From: P [REDACTED]
Sent: 0 [REDACTED]
To: I [REDACTED]
Subject: RE: Request for further information AW/302/20/HH
Attachments: We sent you safe versions of your files; Garage_Plan.pdf; TQRQM20311132058107.pdf; TQRQM20311133158162.pdf

Ref: AW/302/20/HH - 4 West Drive. PO21 4LY

Plattegrond / Plan

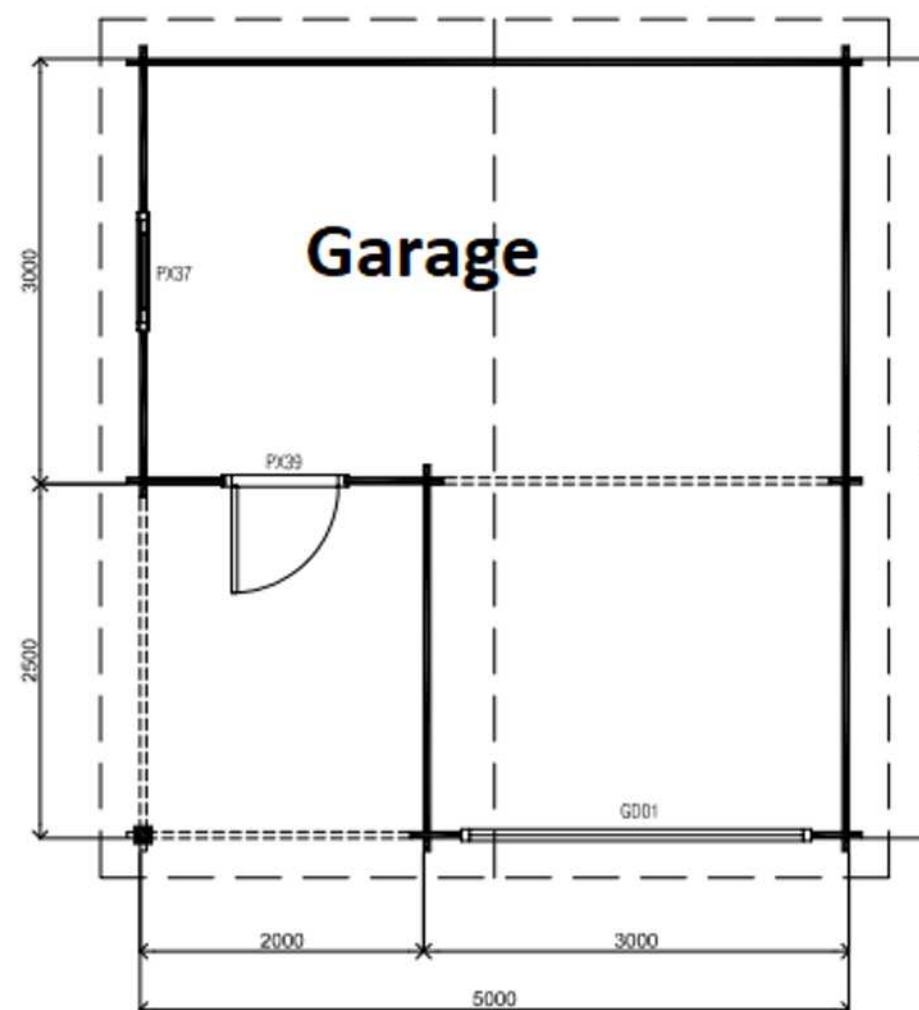
Upon further inspection, I noticed the new plans you sent yesterday with the room label did not measure to scale however the original did. Please amend.

Pittard_4_West_Drive

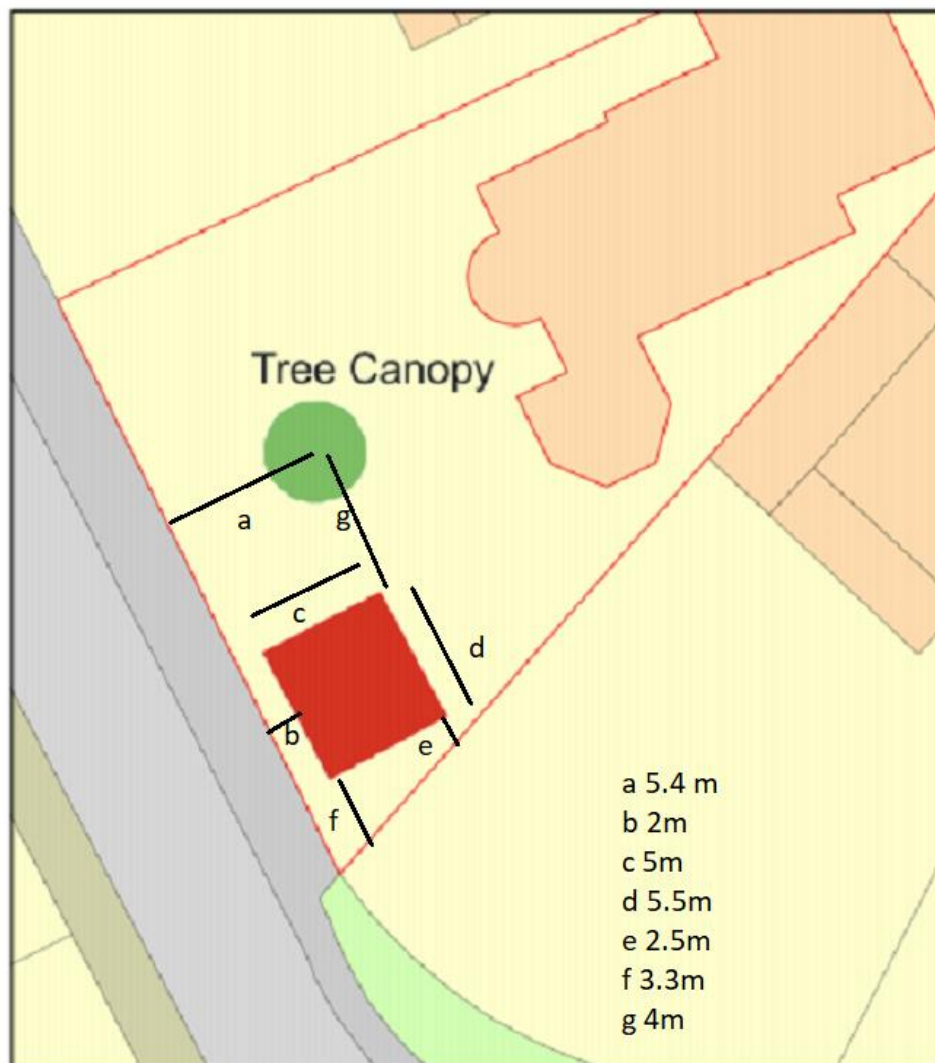
Unfortunately, the new Location Plan received does not measure to scale. Along with this, as you will be altering the red outline for the Location Plan, the Block Plan will also need to be amended as these red lines need to match.

Unfortunately, this new block plan submitted and the dimensions listed do not measure to scale. Please amend or with your permission I can add the dimensions to the original block plan submitted.

Please resubmit the block plan with dimensions in PDF format.
